PROJECT NO. PR-2021-006070  
Application No. SI-2021-01888

# Memorandum

**Re:** Westpointe40 South Site Plan DRB Comment Responses (PR-2021-006070)

SOUTH SITE PLAN

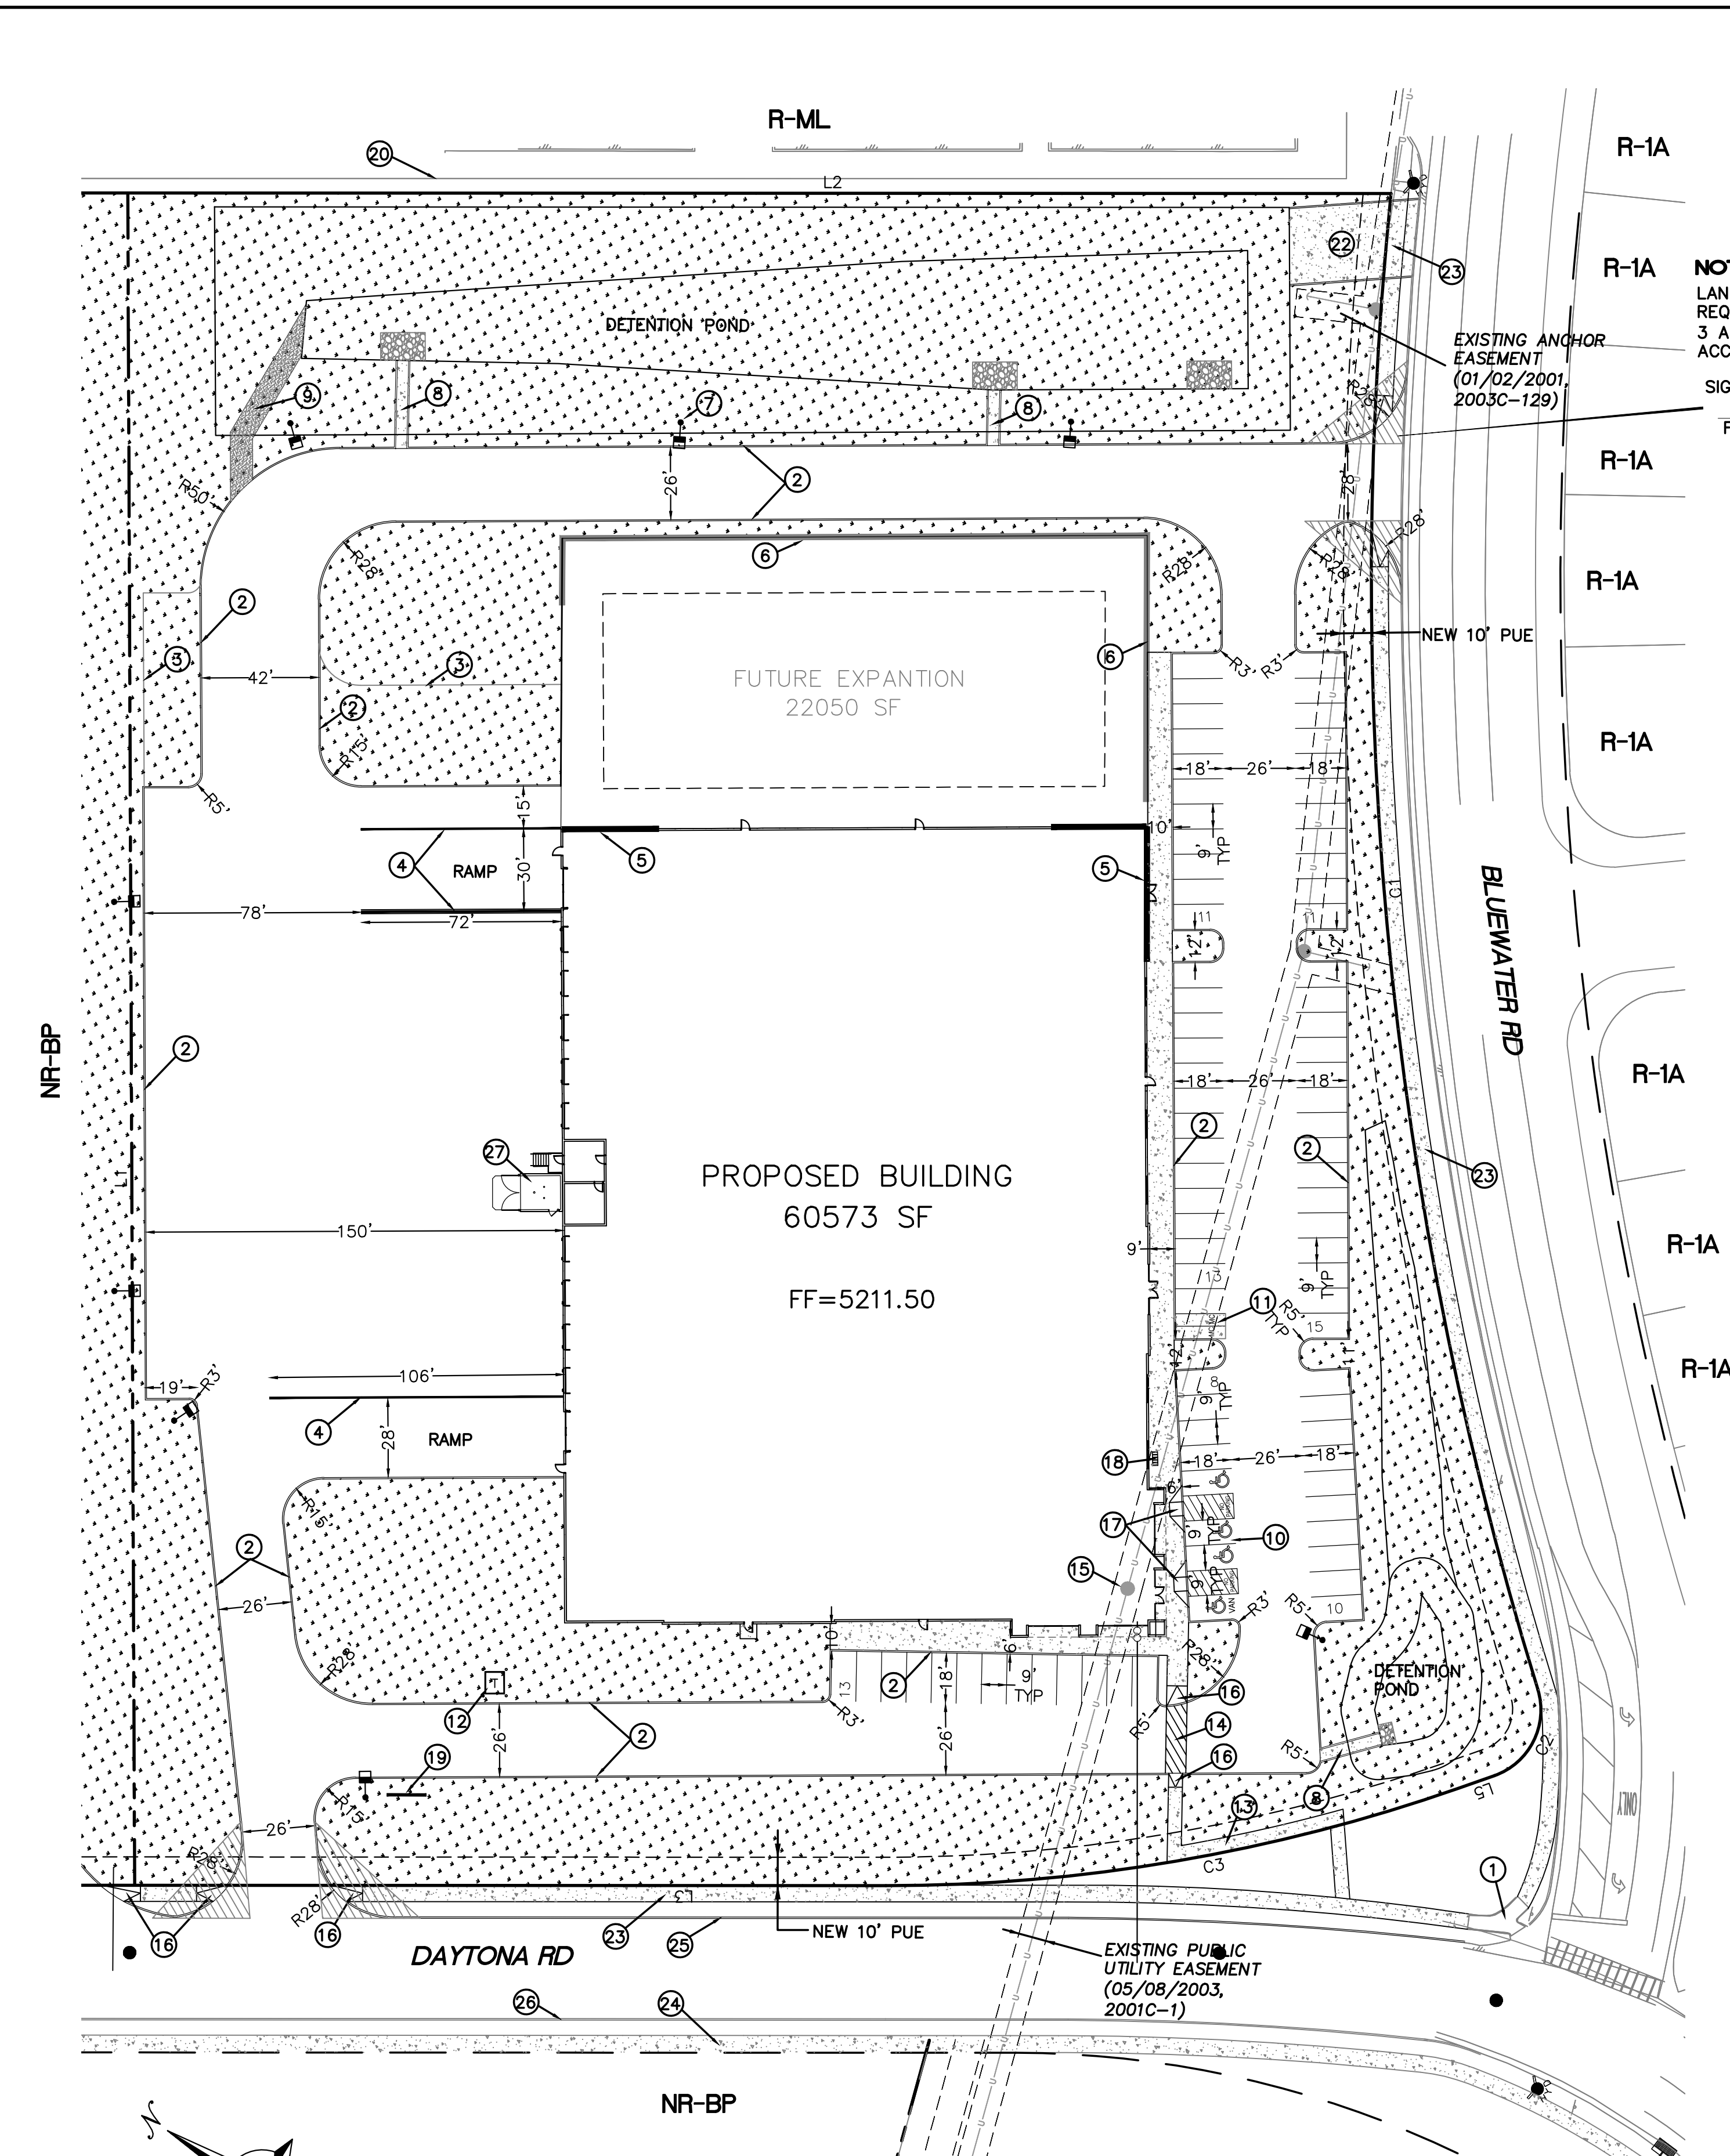
- *Understood. The project has been designed to comply with the NR-BP zone district regulations.*
3. Dimensional standards per IDO section 5-1. Clarify different setback notes on plat.

- *The ADA parking requirements have been added to the parking calculations.*
5. Use intersection clear sight distance for Bluewater Road. Provide these clear sight triangles on the landscaping plan.

1. The warehouse is an industrial use and will require a landscaped edge buffer area at least 25-feet in width along all boundaries with non-industrial development. The North Site Plan has multi-family on the eastern boundary. The South Site Plan has multi-family on the eastern

boundary and single family on the southern boundary (please see the attached comments on Industrial Buffers). On the South Site Plan, a landscaped edge buffer area at least 15-feet in width must be provided along the eastern boundary between the detention pond and the eastern property boundary.

- *Please see the response to Code Enforcement comment #8.*
5. The building setbacks are depicted on the Site Plan as 5-feet for the front, and 0-feet for the sides and rear. The setback requirements in the NR-BP zone district are 20-feet for the front, and 10-feet for the sides and rear. The setbacks for the buildings based on the NR-BP standards appear to be met. Confirm that the setbacks are being met and note the correct required setback standards and the setbacks for the proposed buildings on the Site Plans.

- *The setbacks on the site plan have been updated to correctly reflect the NR-BP zone district standards, and the plan complies with these setbacks.*

- *Sight distance triangle for the intersection of Bluewater at Daytona has been added to the plans.*
  6. Obtain Fire-1 plan for the submittal set.

- a. A 15-foot buffer has been accommodated on the east side of the drainage pond for the property and is dimensioned on the site plan.
2. The project and application numbers need to be added to the Site Plan prior to distribution of the Site Plans to the DRB members for their e-signatures.

- *The setbacks have been updated on the site plan.*
6. The Site Plan for the southern portion of the site featuring the proposed 60,573 square foot building is phased, with 22,050 square feet of future expansion depicted. Confirm if the improvements and infrastructure depicted on the Site Plan for the southern portion of the site will be phased as well or if the improvements and infrastructure will be constructed in their entirety as depicted on the Site Plan during the first phase.

SOUTH SITE BUILDING ELEVATIONS

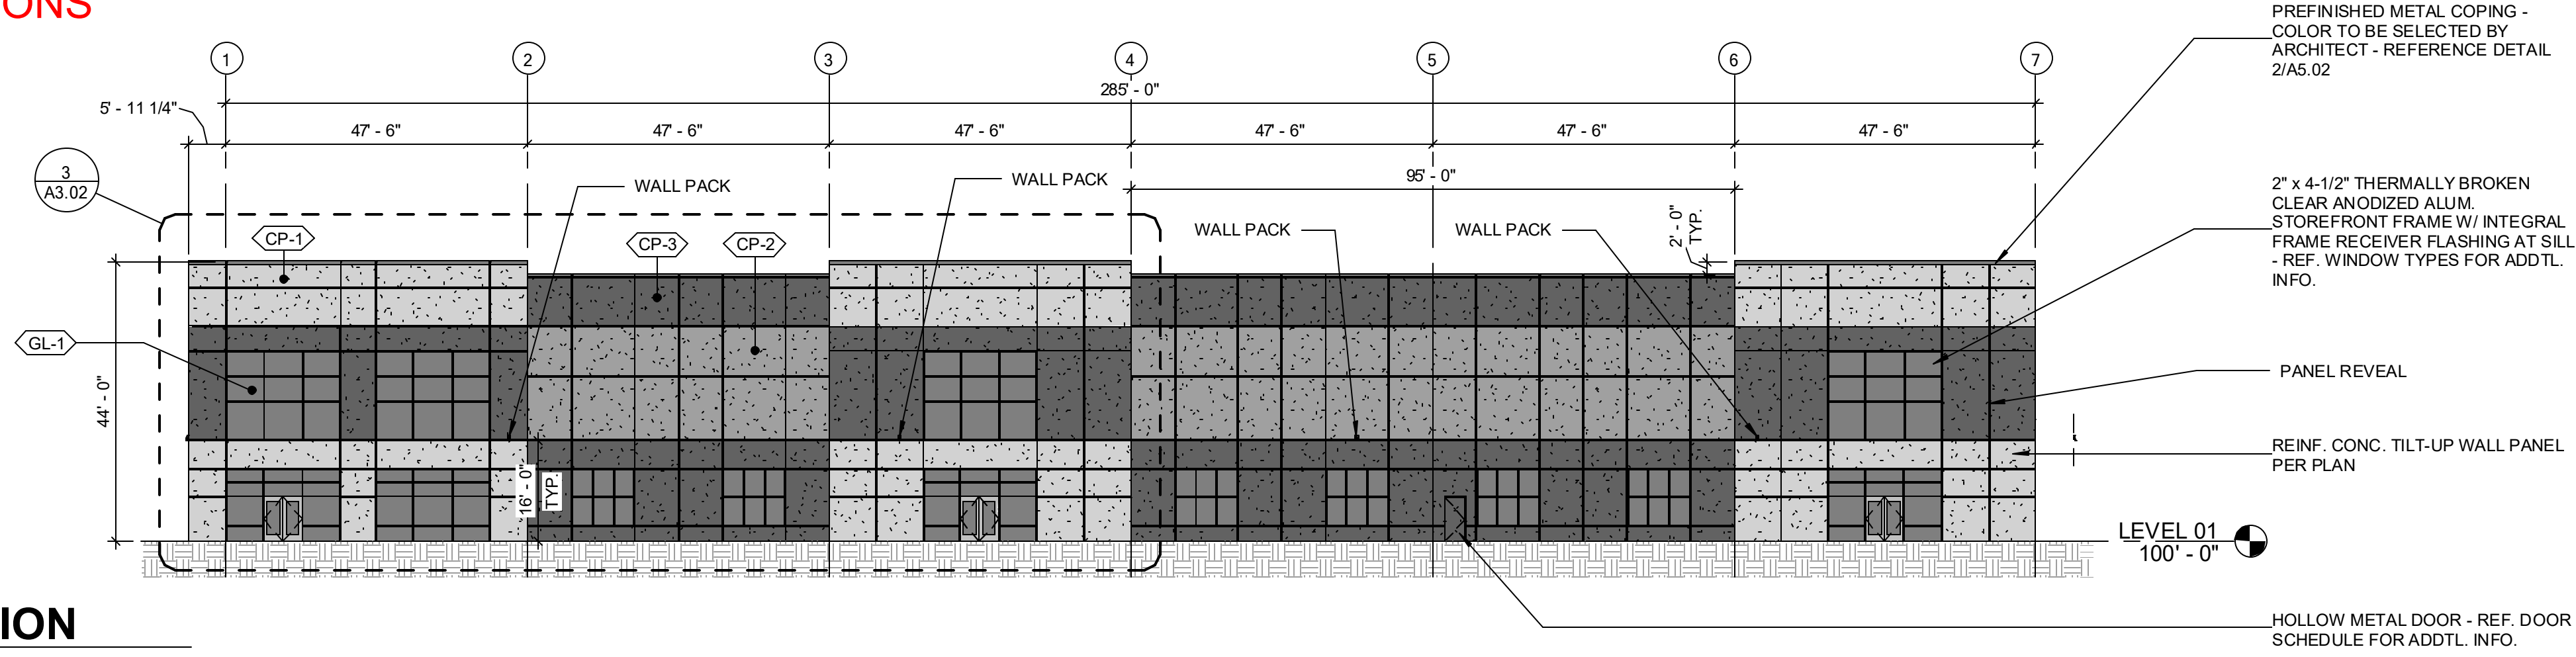
8. Additional detail needed for meeting Façade Design general standards, IDO section 5-11-E.
  - *Despite the large size and function of the building, a human scale is provided along the primary building façade through a differentiation in colors and use of windows and doors around entries.*

- *The building is setback more than 30 feet from Bluewater Road, so it does not meet the definition of a street-facing façade and therefore is not required to meet the standards outline in Section 5-11(E)(2)(a)2. However, the applicant has taken care to provide visible primary pedestrian entrances and the use of ground floor windows to improve the overall look and feel of the building from the parking lot.*

- *While it is not considered a street-facing façade, the south elevation breaks up its length using a change in parapet heights and building articulation every 50 feet, as well as using multiple colors along the entire length of the façade.*

BLUE SKY DISTRIBUTING ALBUQUERQUE, NM	DRAWN BY pm
	CONCEPTUAL GRADING AND DRAINAGE PLAN	DATE 11-4-21
11-4-21 RONALD R. BOHANNAN P.E. #7868	TIERRA WEST, LLC 5571 MIDWAY PARK PL NE ALBUQUERQUE, NEW MEXICO 87109 (505) 858-3100 www.tierrawestllc.com	DRAWING 2020088-60K.DWG
		SHEET # GR-1
		JOB # 2020088

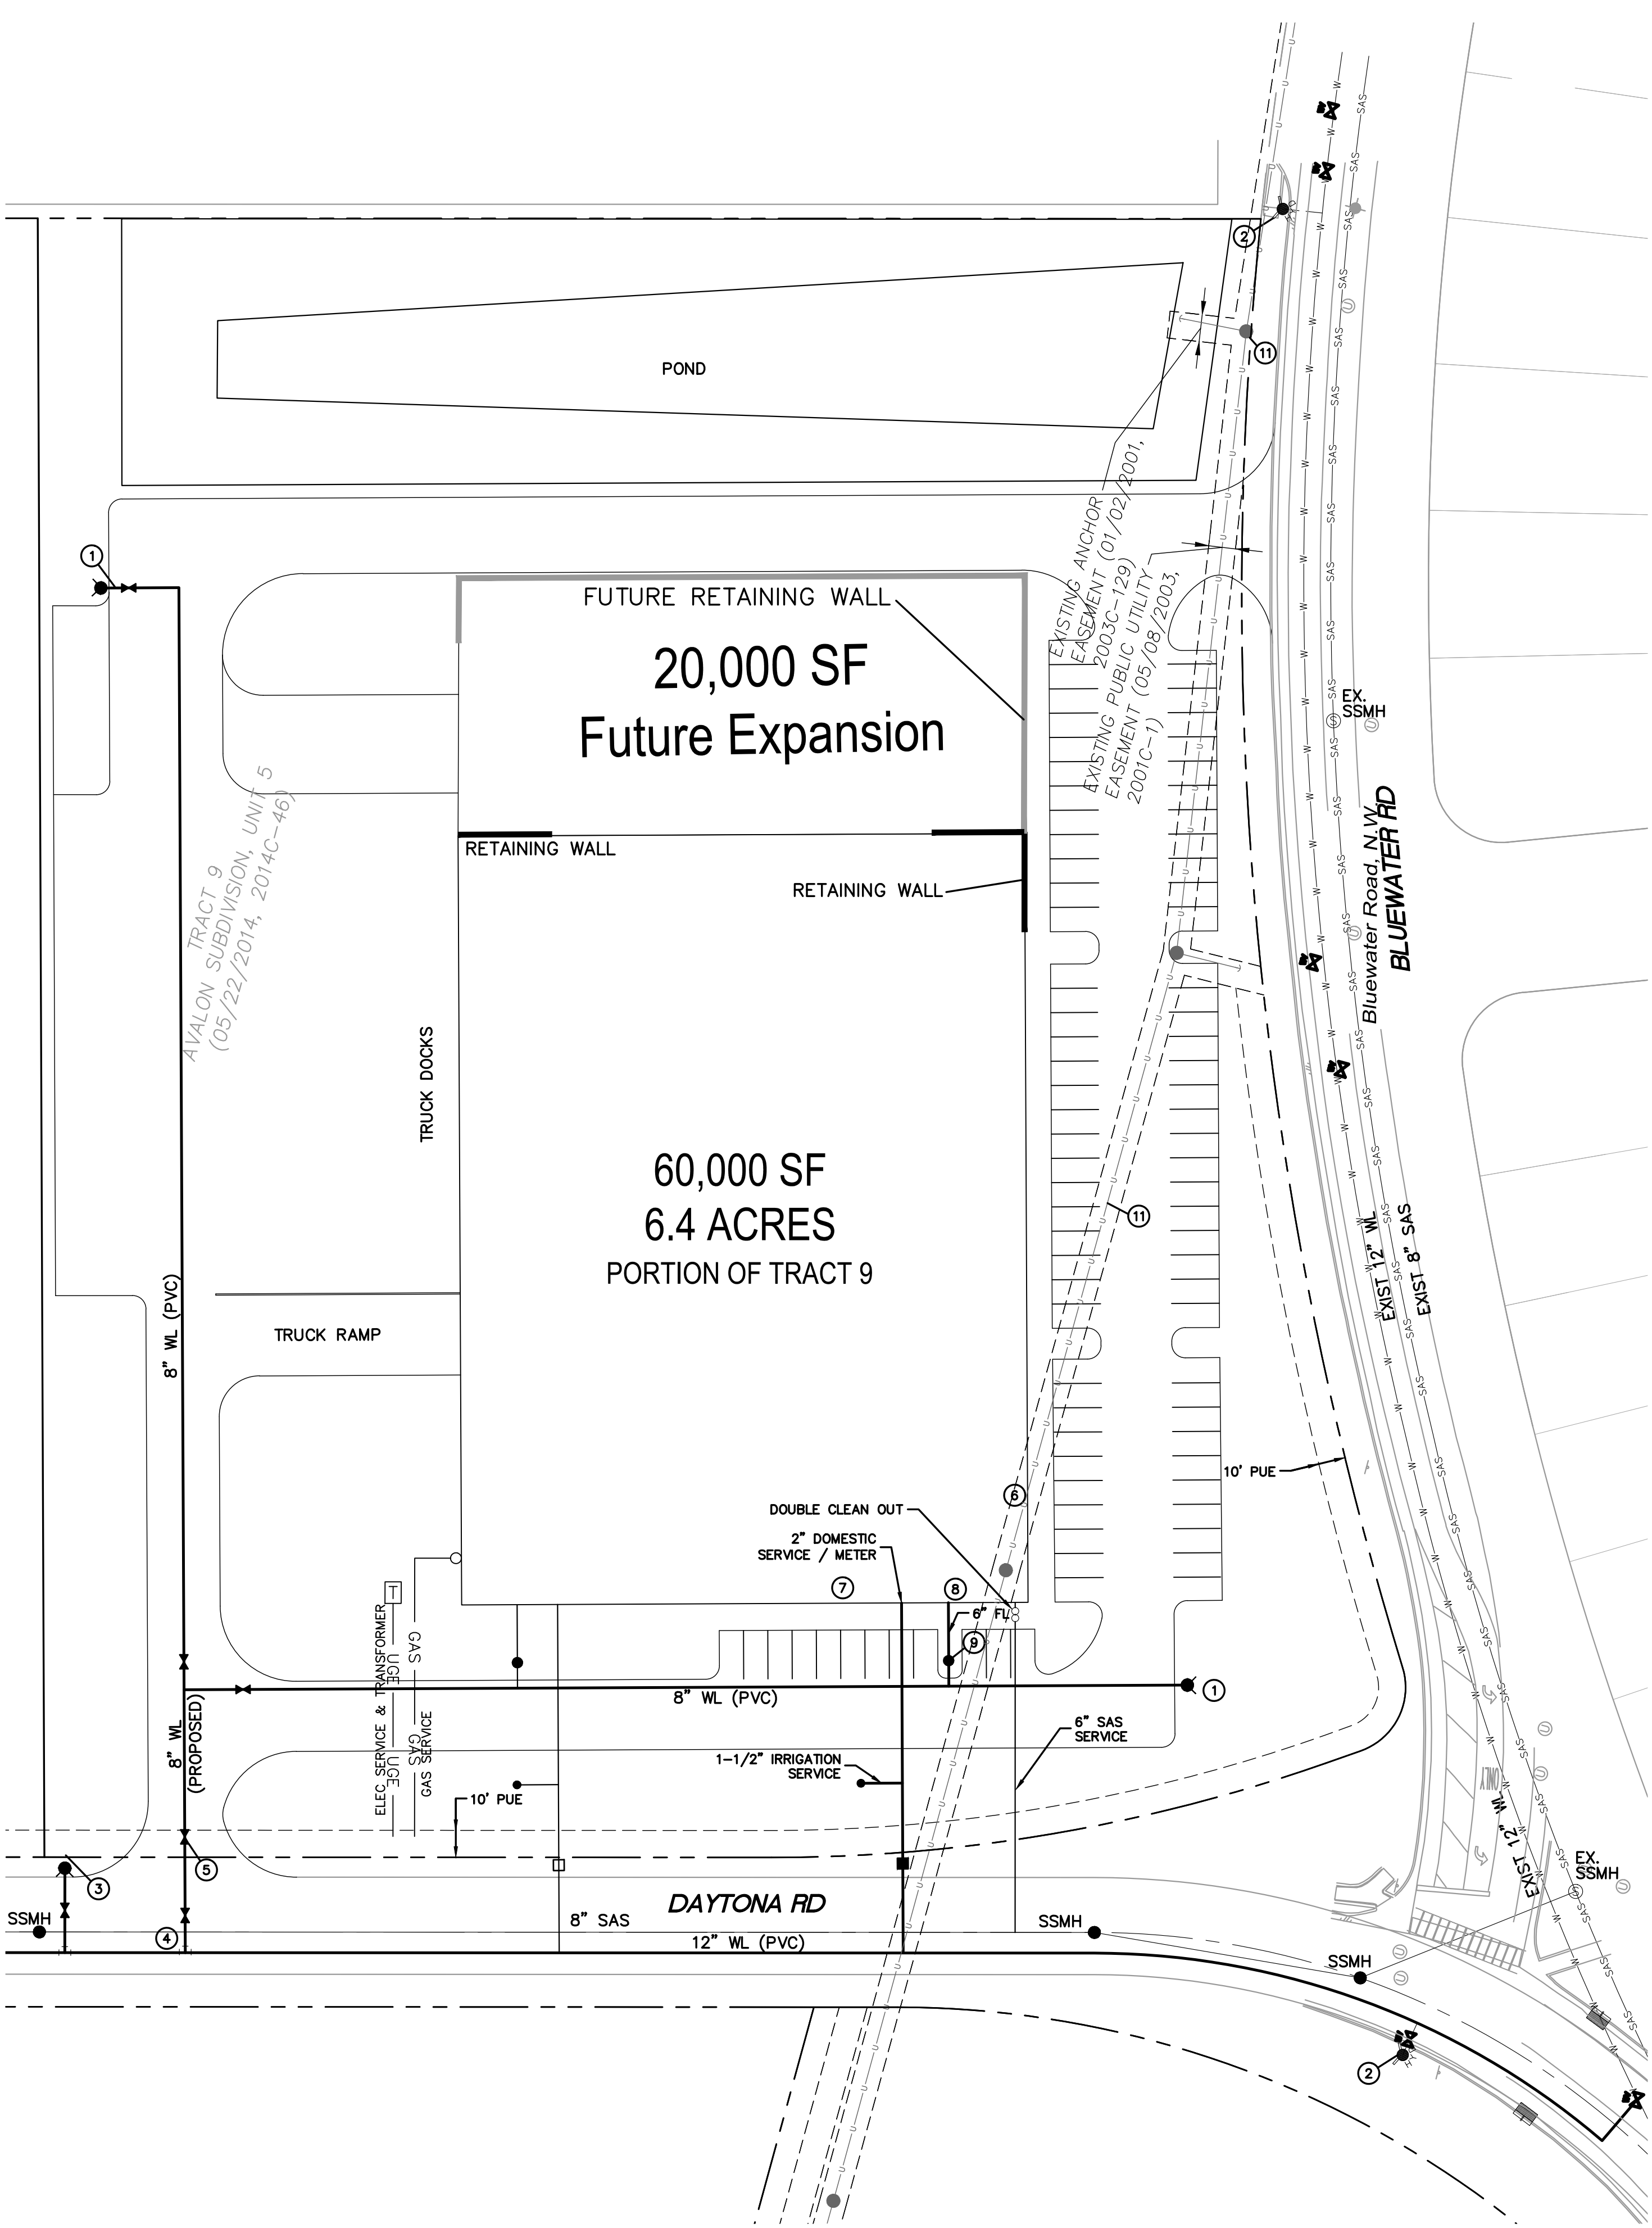
2. This project is within the adopted service area.
3. Pro rata is not owed for this property.
4. Utility Plan:
  - a. The meters need to be at the right-of-way line. The WUA will not maintain a line onsite to shorten the private water line lengths. Separate service connections are required for each meter.

- b. The required water main has been revised to a ten-inch. Please revise the call-out to be consistent with this requirement.
    - *An updated utility plan has been provided with the supplemental submittal.*
